Rezoning Transportation Analysis

Petition Number: 2020-055

General Location Identifier: Tax ID 04739109

Revision Log:	Date	Description
	05-18-2020	First Review

NTS  
VICINITY MAP

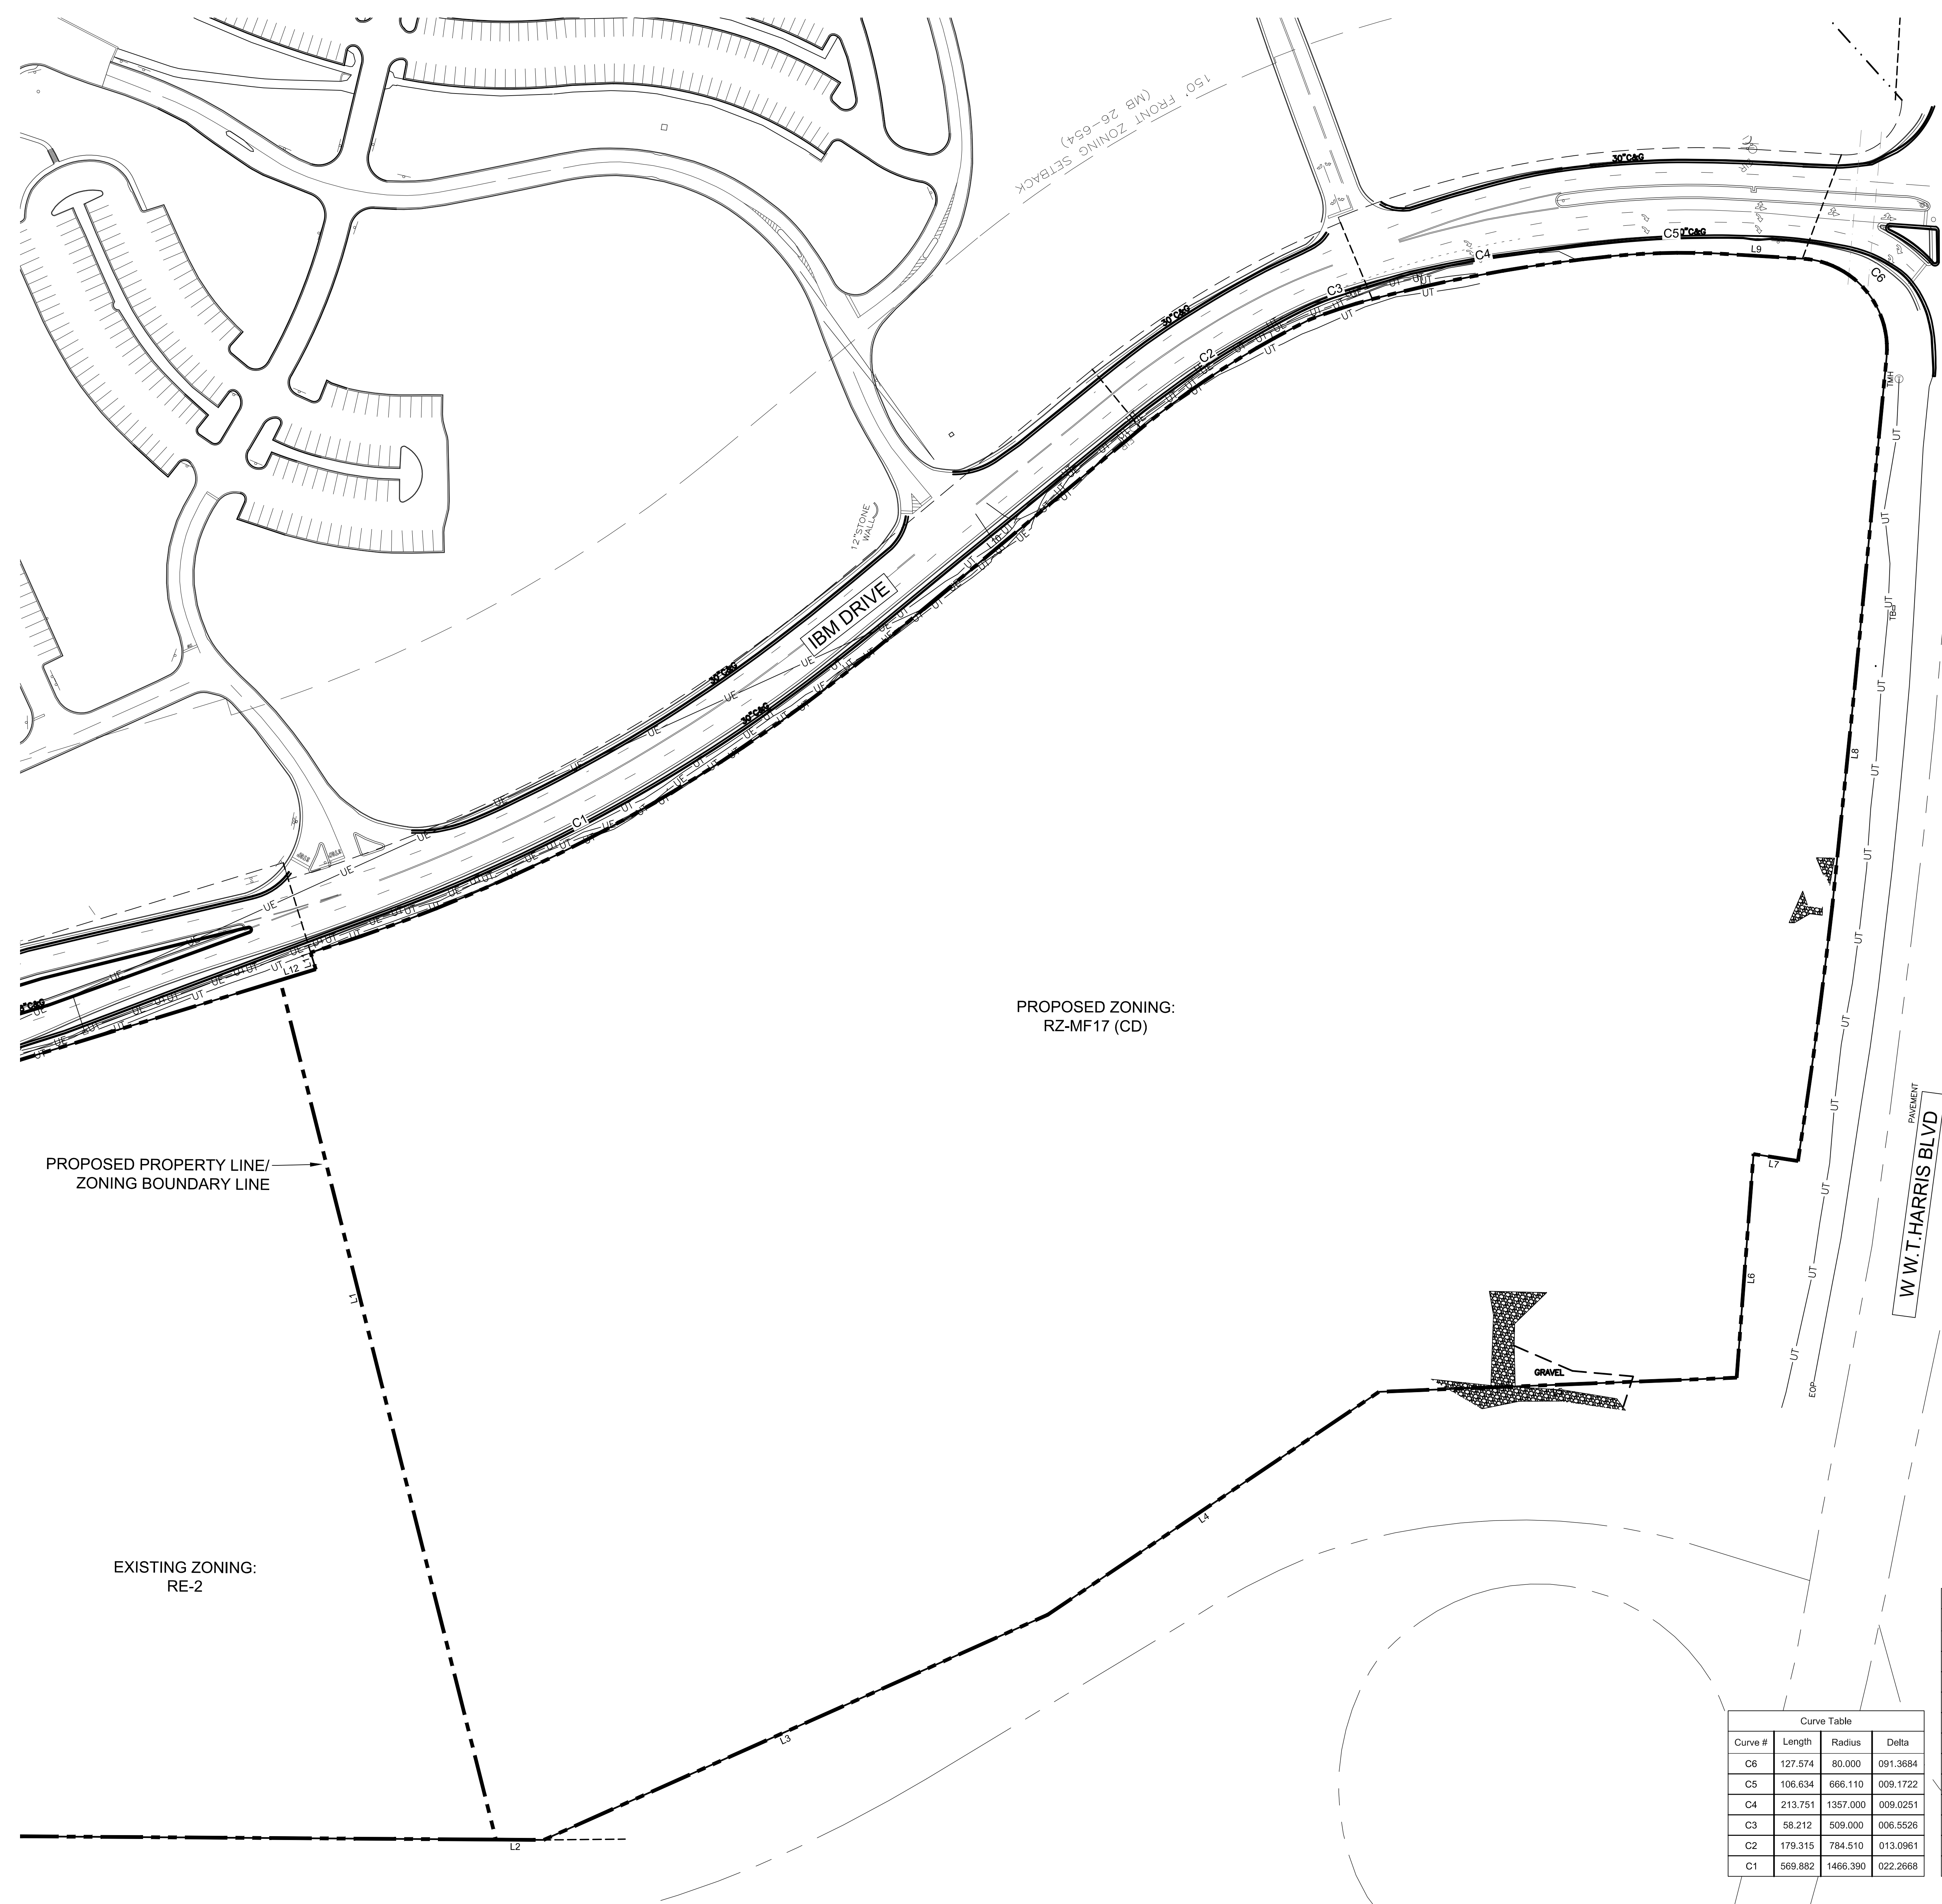
The site plan should show the curb and gutter labeled and dimensioned from the centerline for each road.

- The City ordinance gives CDOT the authority to determine driveway locations to public streets. Therefore, the petitioner should revise the site plan and conditional note(s) to commit to eliminating the northernmost proposed access point and creating an access point opposite the second Innovation Park Driveway. This comment was previously provided to the development team at a pre-submittal meeting.

- The petitioner should revise the site plan and conditional note(s) to provide left turn lanes from IBM Drive into the site.
